RE: Comments and questions on SUB19-002

East Seattle School proposed parcel subdivision

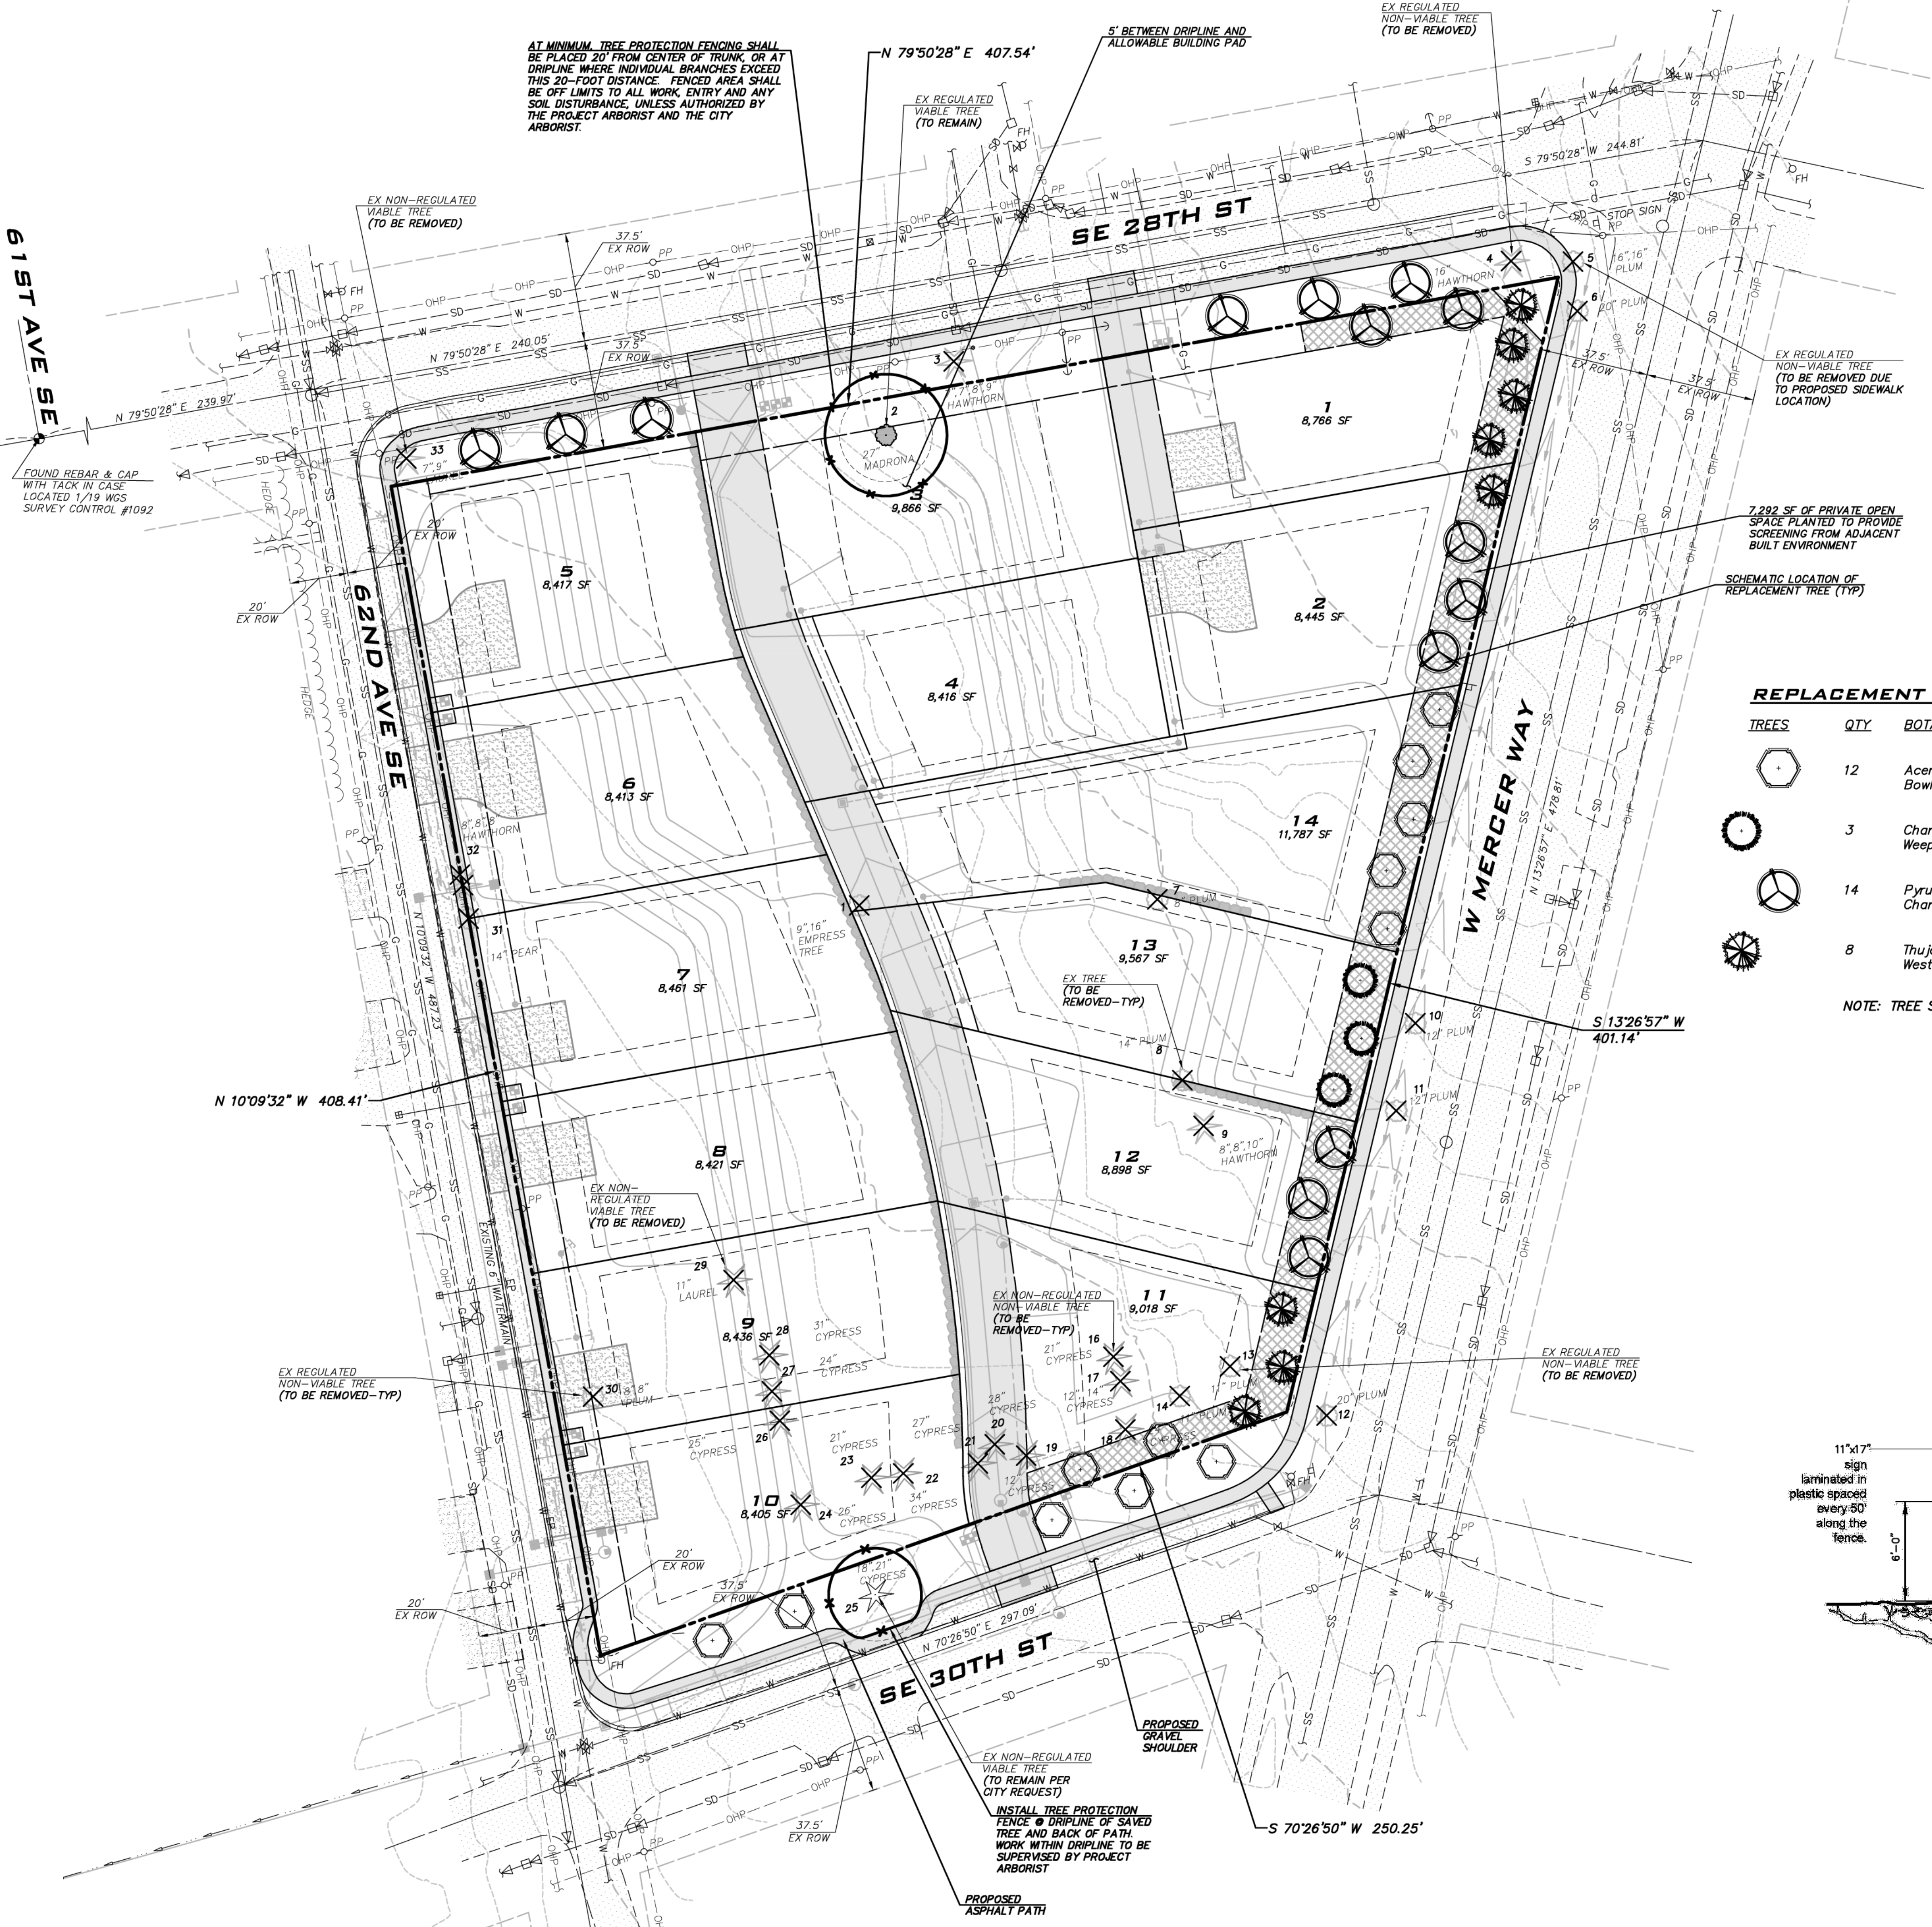
- 1) Promises made 15 years ago, and broken: see M I Reporter 11/24/2008 noting O’Brien wanted to create more athletic facilities for Island youth and stated “ When we are done, it will be a great facility for kids and families”. Promise broken! More in the Puget Sound Business Journal, too lengthy to quote but you get my point. No trust in this owner or his team!
- 2) The description in the Notice of Public Hearing notes “The proposed development contains a private easement for open space and a community open space tract.” If the community open space is the 3’ triangle at the northeast property corner, this is absurd at best. At a minimum go to 13 homes and give back the volleyball area that is currently there, and was promised.
- 3) Trees – the arborist report is from 2019, and must be updated as it has expired. I see the south trees every day from my home, they do NOT

appear to be diseased nor should they be removed. At a minimum, if and when the proposed 14 lots (MAXIMUM should only be 13, still promise broken) are permitted for single family homes, trees on each lot should be addressed individually. NO CLEAR CUTTING Please require the planting on West Mercer Way to be dwarf trees or perhaps a hedge, with an enforced maximum height of 25'. The neighborhood should not suffer loss of a view corridor by this development. A myriad of new trees would not be necessary if the developer kept the magnificent existing ones....just sayin'!!
